Please show 2010 ADA Standards compliance with door, toilet room and fixture clearances.

86 PONDFIELD ROAD WEST, BRONXVILLE, NEW YORK 10708
 DIAMOND COVE GENERAL STORE
 RESTROOM INTERIOR ELEVATIONS AND MOULDING DETAILS
 NASTASI VAIL DESIGN, LLC
 MRS. ALEXANDRA WIGHT
 GENERAL STORE, GREAT DIAMOND ISLAND
 PORTLAND, MAINE 04109

DATE: 1/24/18
 SCALE: 3/4"=1'-0"
 SHEET: 11.5

2 RESTROOM: WAINSCOT & MOULDING DETAILS
 Scale: FULL SIZE

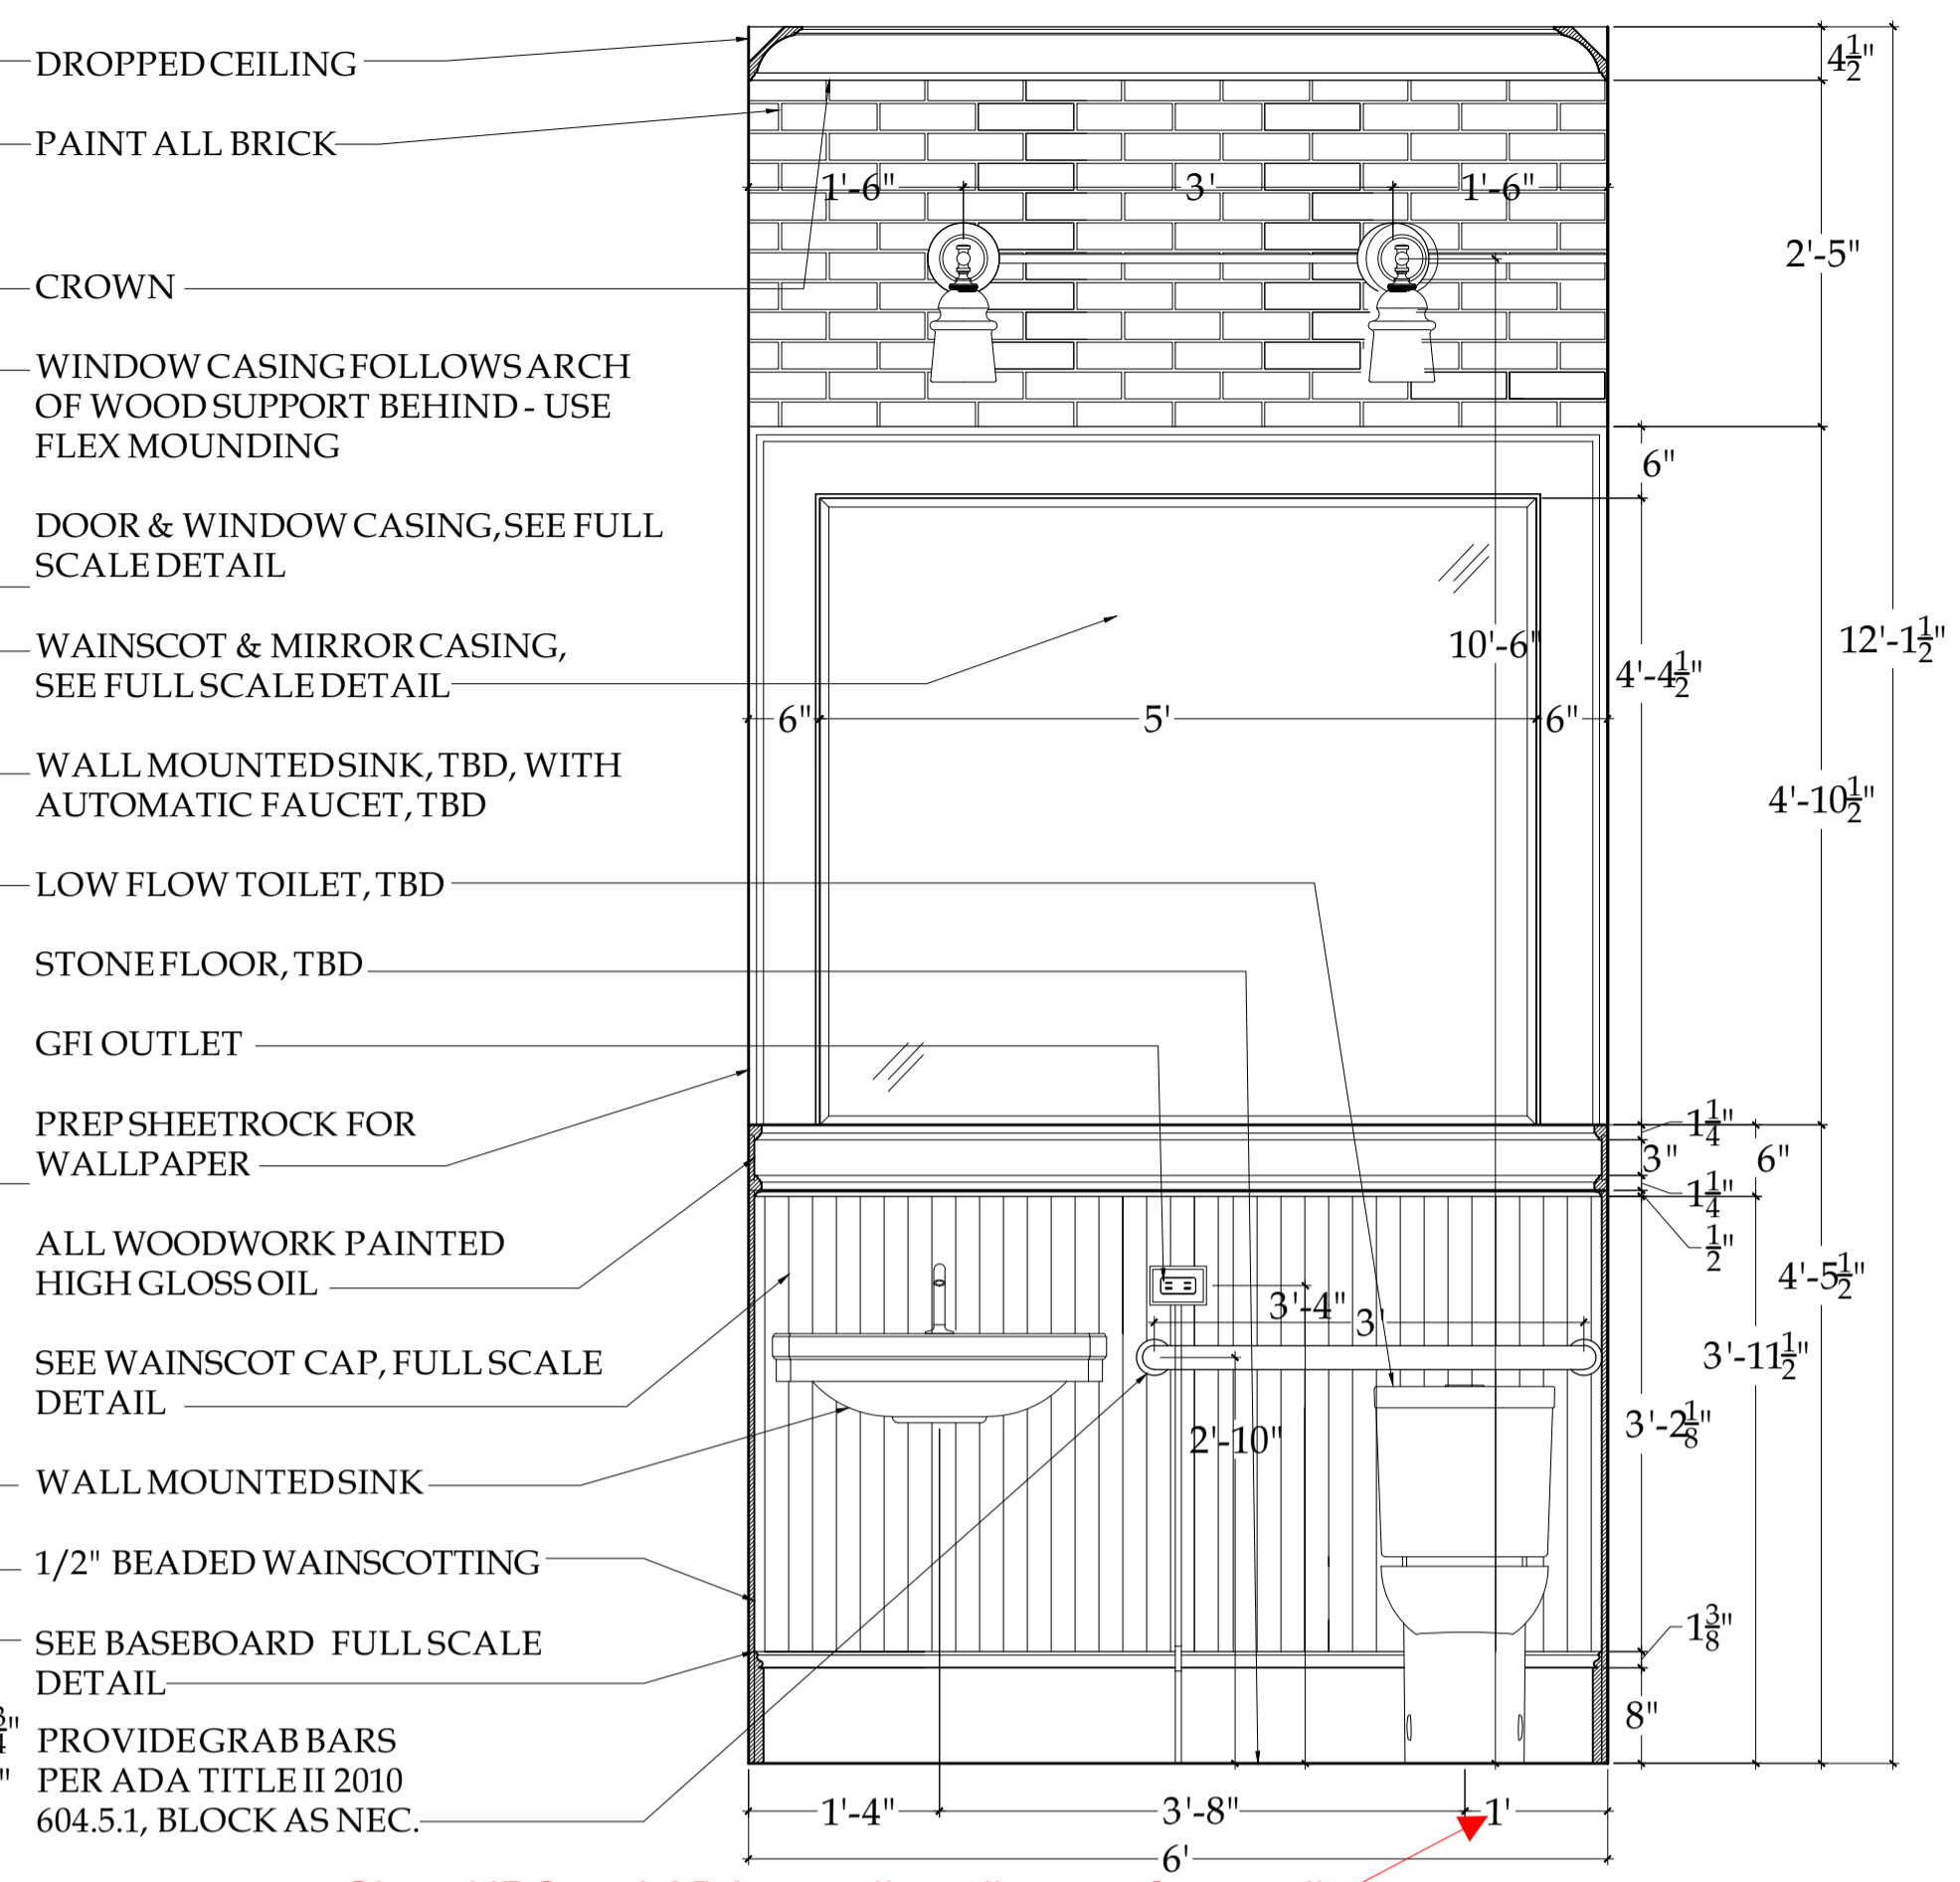
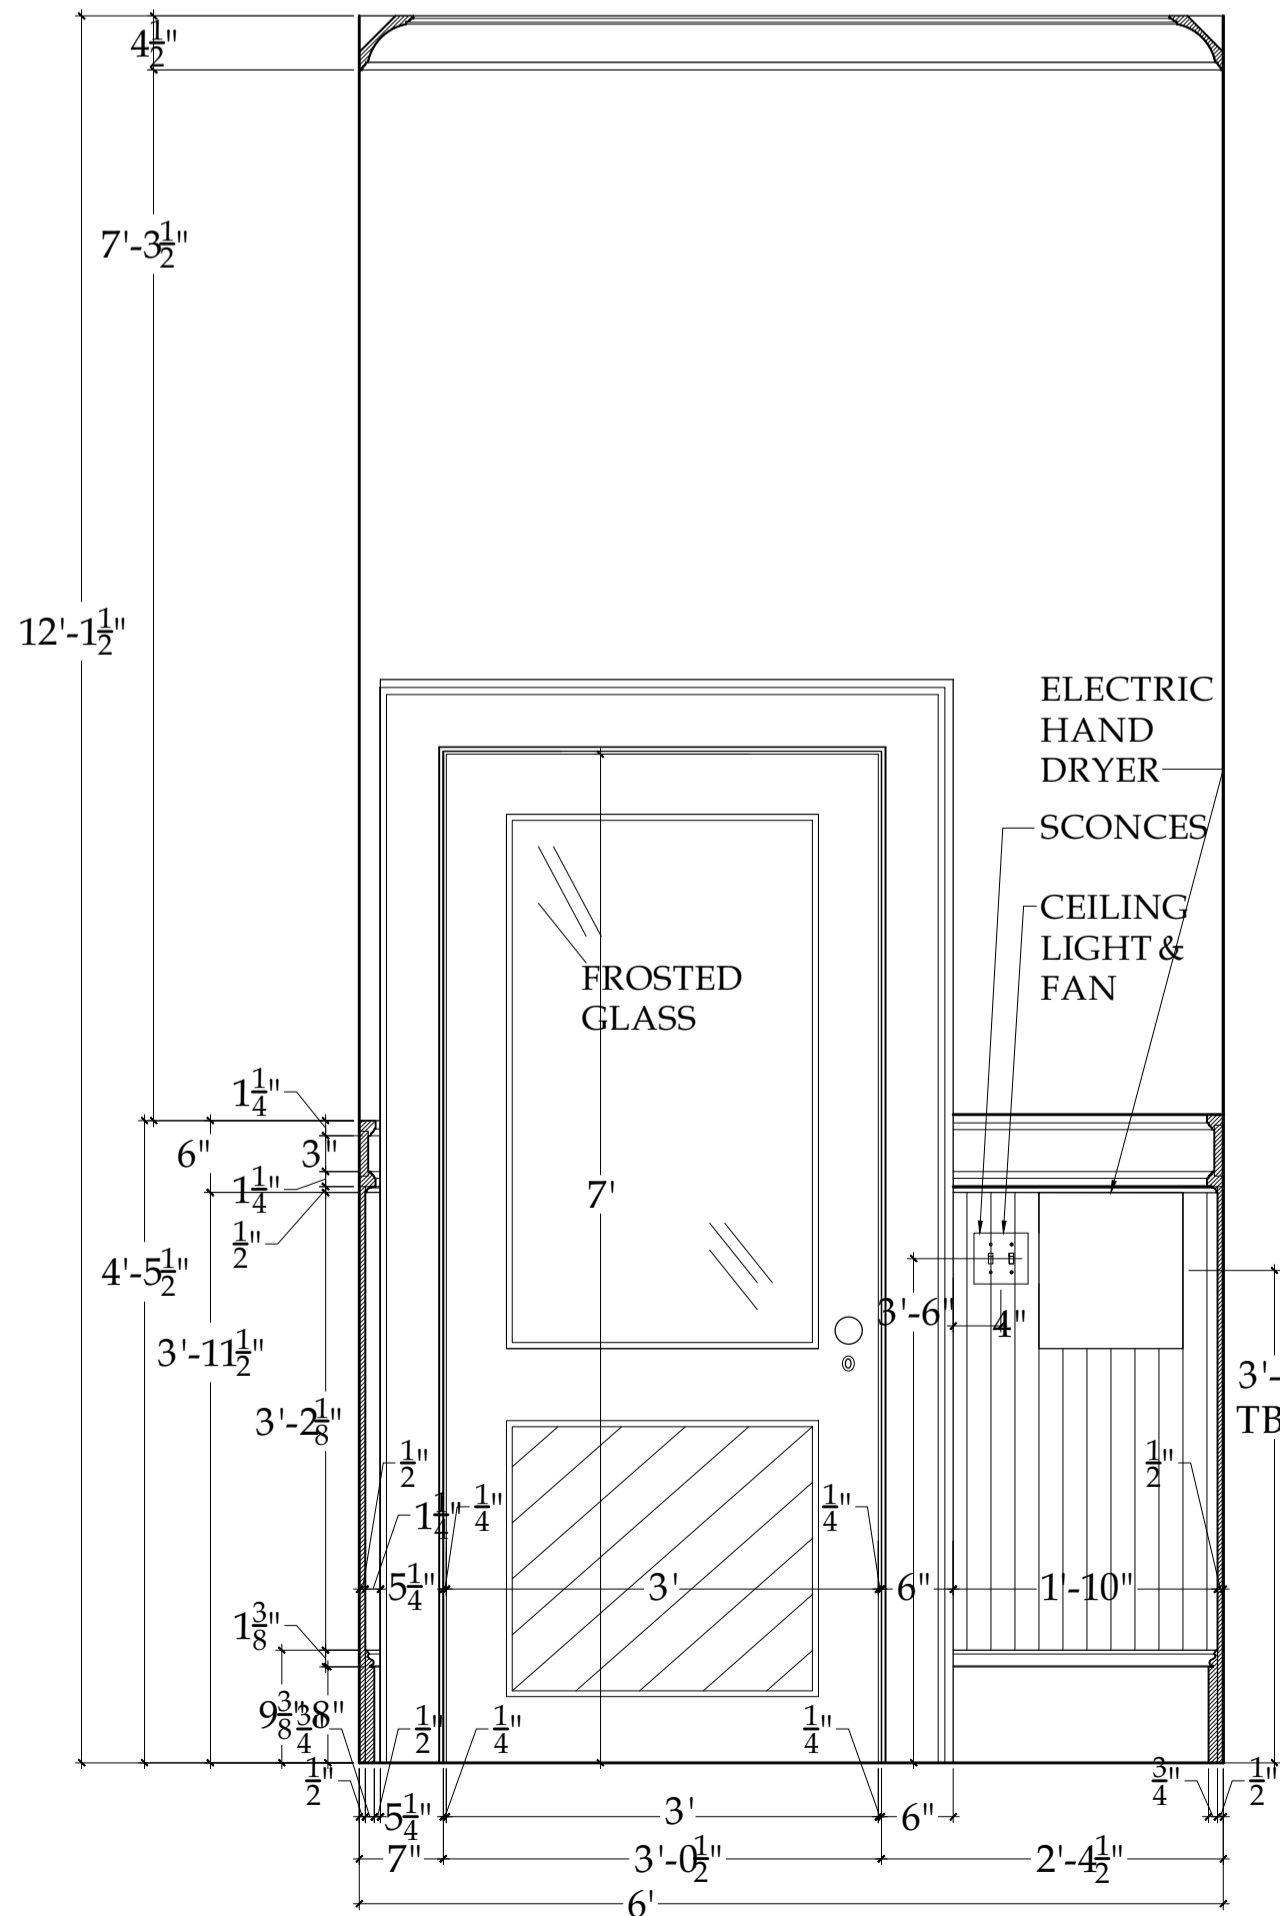
Show ADA compliant knee and toe clearance below sink

Show UPC and ADA compliant distance from wall
